Subject: Lingards Road, Slaithwaite - Revised temporary works proposal

Lingards Road, Slaithwaite - Revised temporary works proposal

Having reviewed the revised temporary works proposal, please find my comments below.

Client				
SB HOMES				
Project				
LINGARD ROAD, SLAITHWAITE				
Detail				
SECTION THROUGH PLOT 23

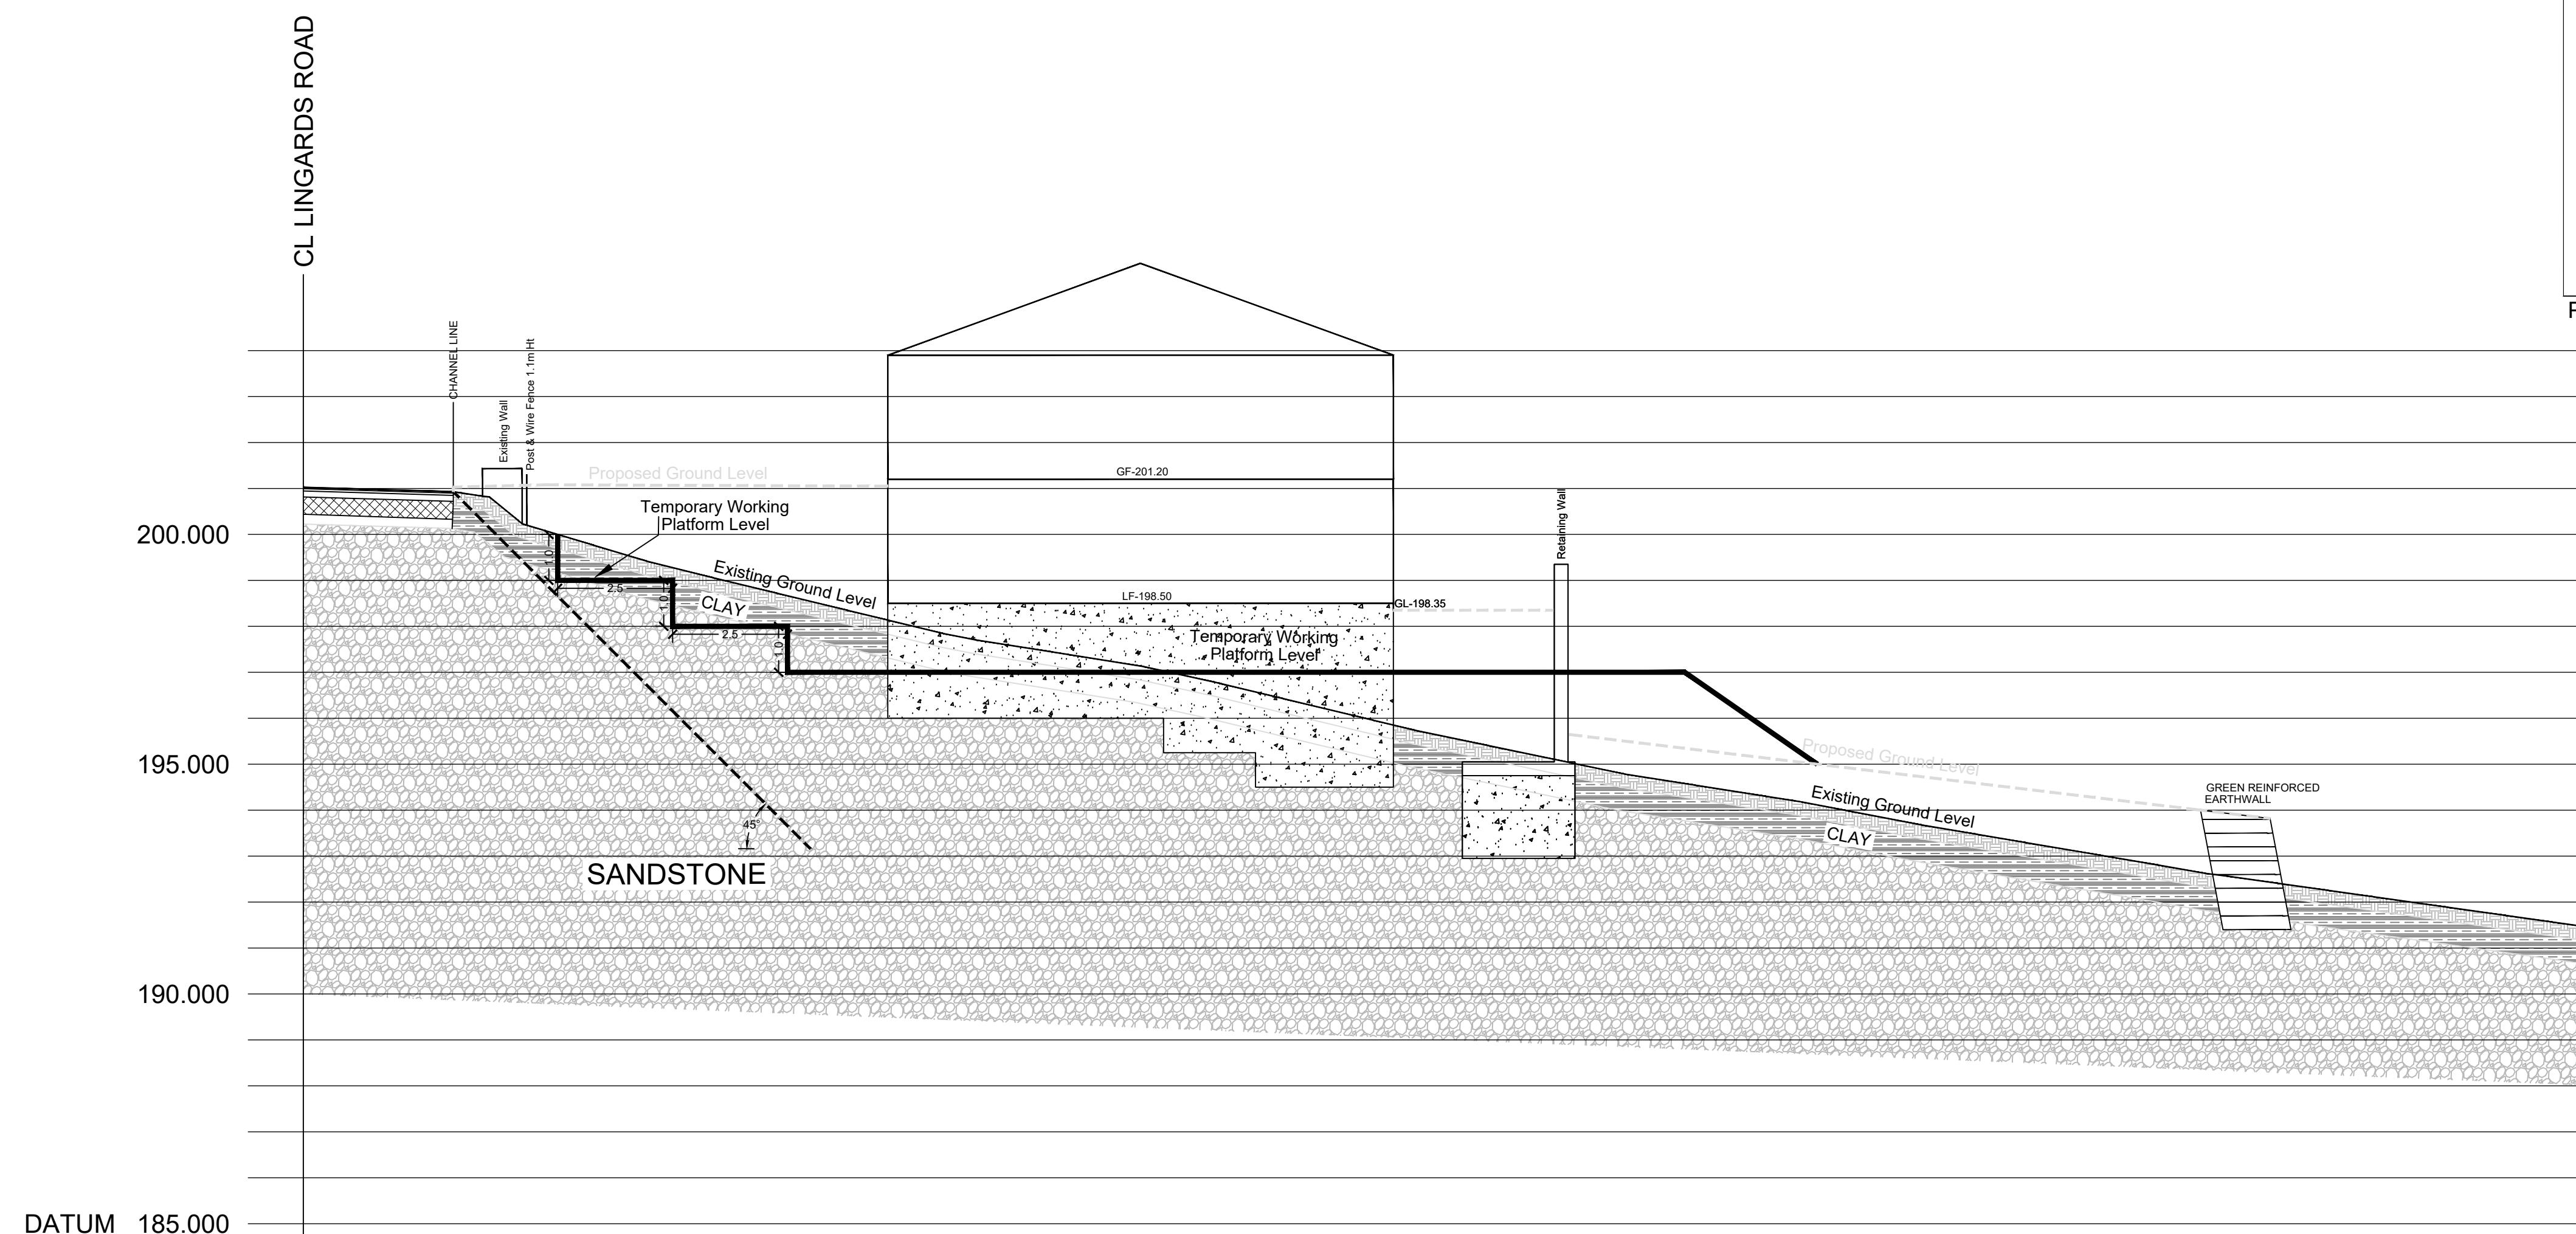
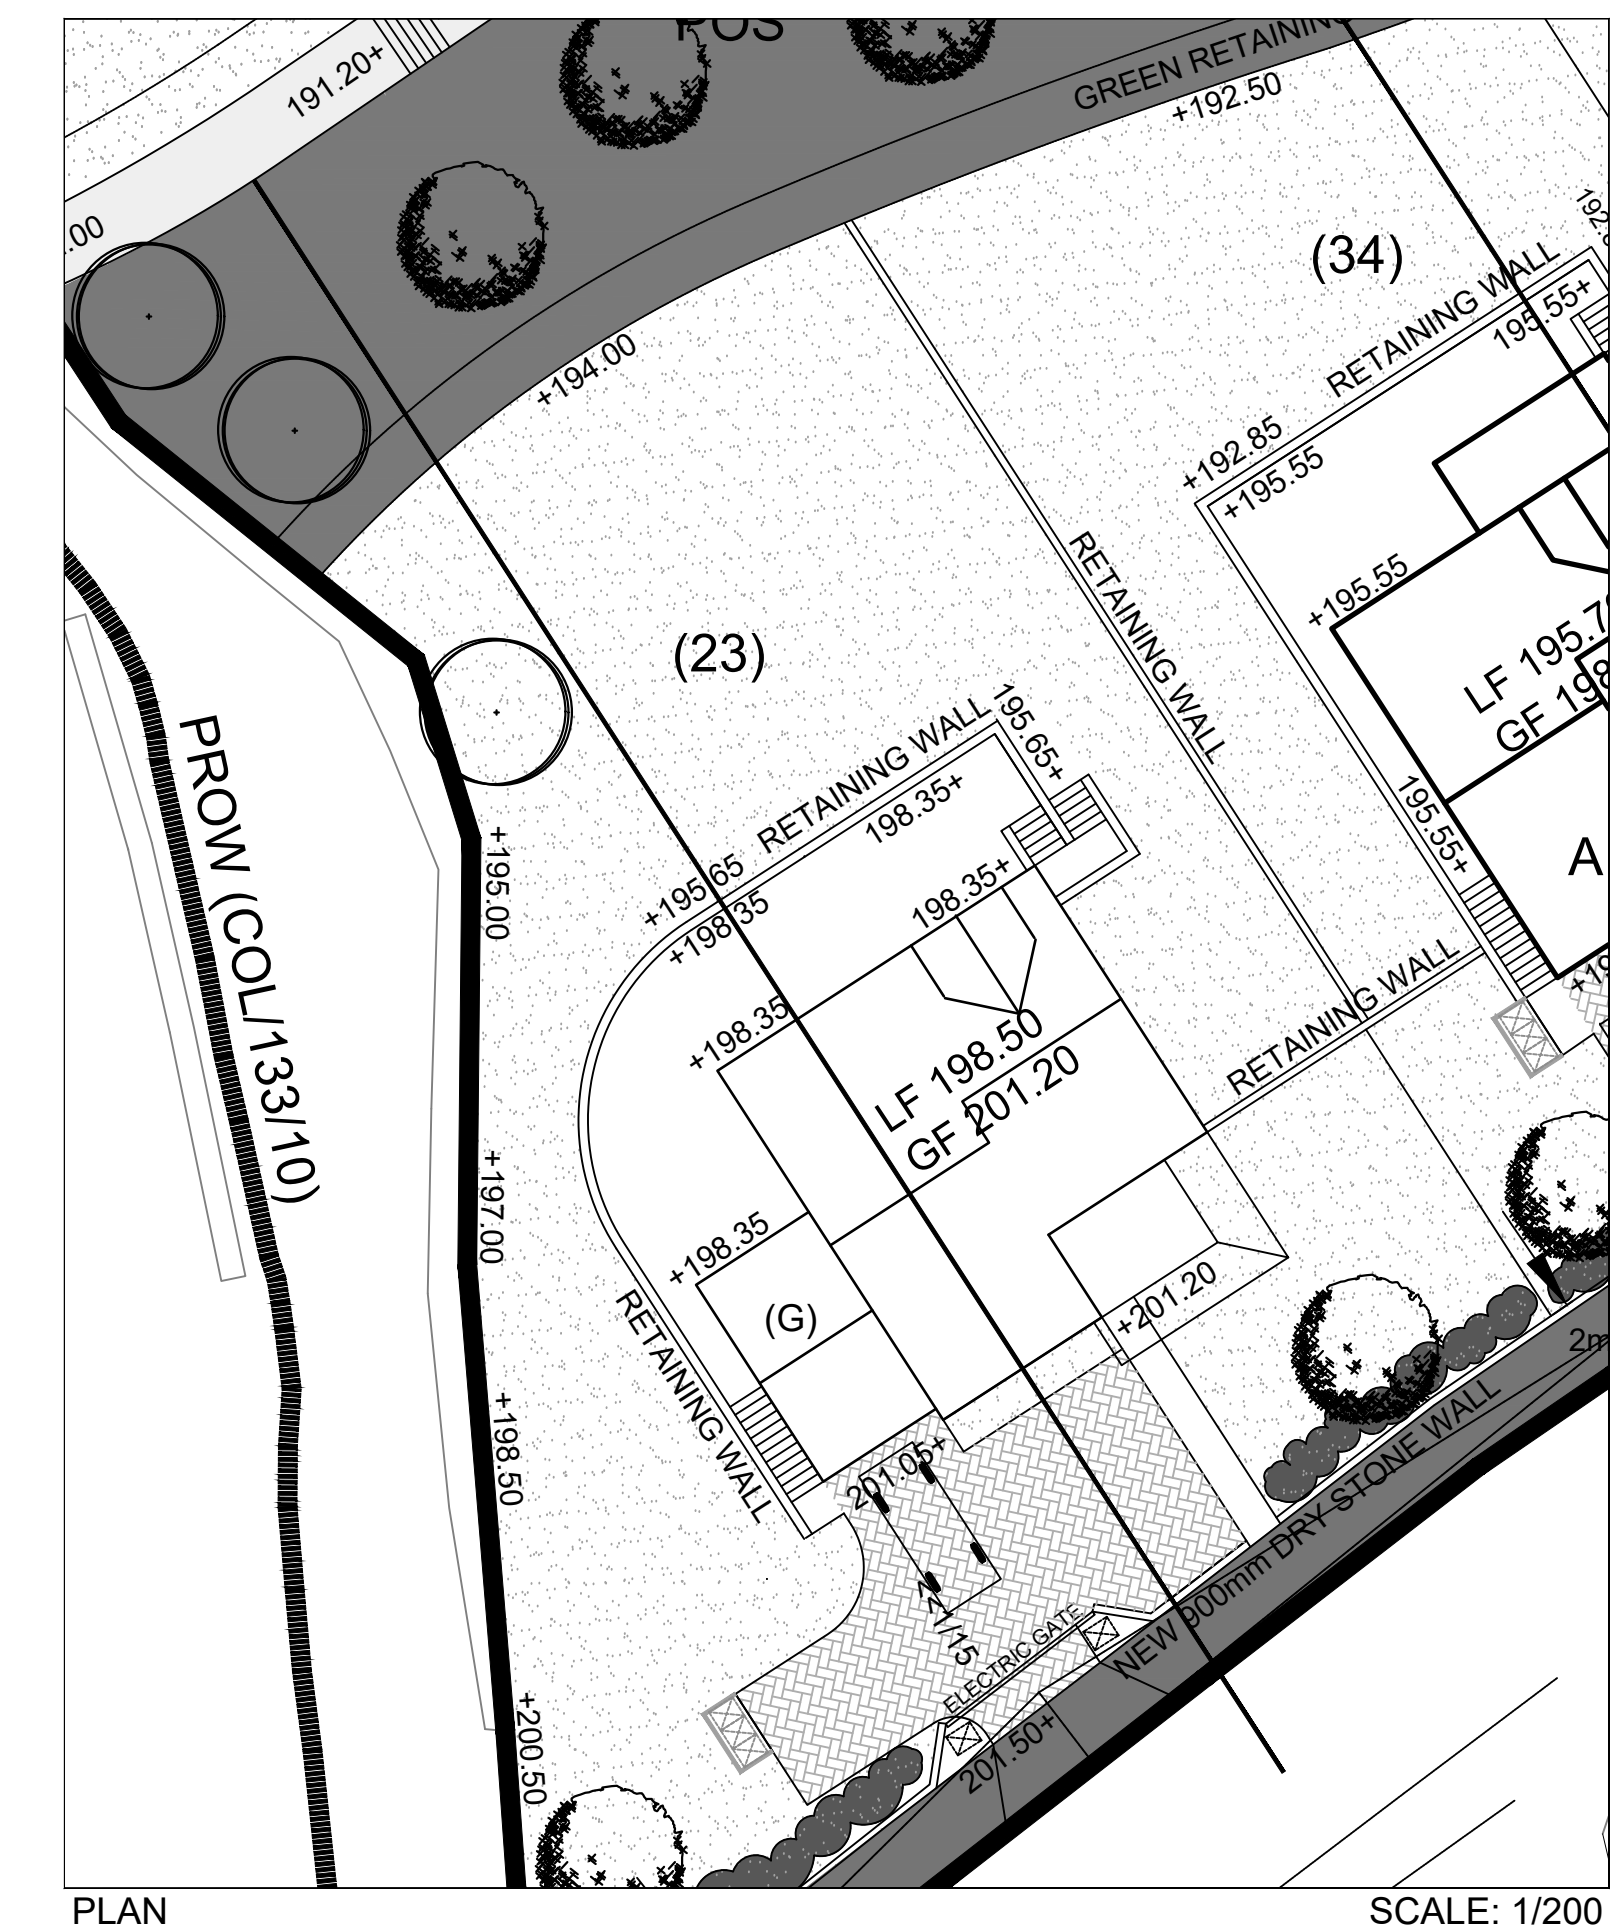
4. The steepest section appears to be at plot 42, immediately south of the site entrance, where a 33-degree temporary benched slope is proposed. However, the greatest perceived risk to the highway is at plot 36 due to the proximity of the proposed excavation to the highway edge and the possibility of groundwater springs in this location. **Once excavation for the temporary works commences, the exposed face will be monitored. If ground water is encountered, a land drain will be introduced connecting into the onsite land drainage system to ensure stability of the temporary works. Full land drainage will be provided to the rear of all the basement retaining walls to the plots along the site frontage.**

6. Some enhanced measures may be required where groundwater seepages are encountered during excavation. It would be prudent for the developer to have immediate access to a supply of coarse sandstone aggregate (e.g. 100mm to 150mm clean stone) and separator fabric (e.g. Terram 1000 or similar) should groundwater be encountered. **The known spring to the front of plot 37 is to be investigated further and picked up and diverted through the onsite land drainage system. Should any further groundwater be encountered, a land drain will be installed and also connected into the land drainage system. Materials will be readily available on site as the basement retaining walls all require a land drainage system.**
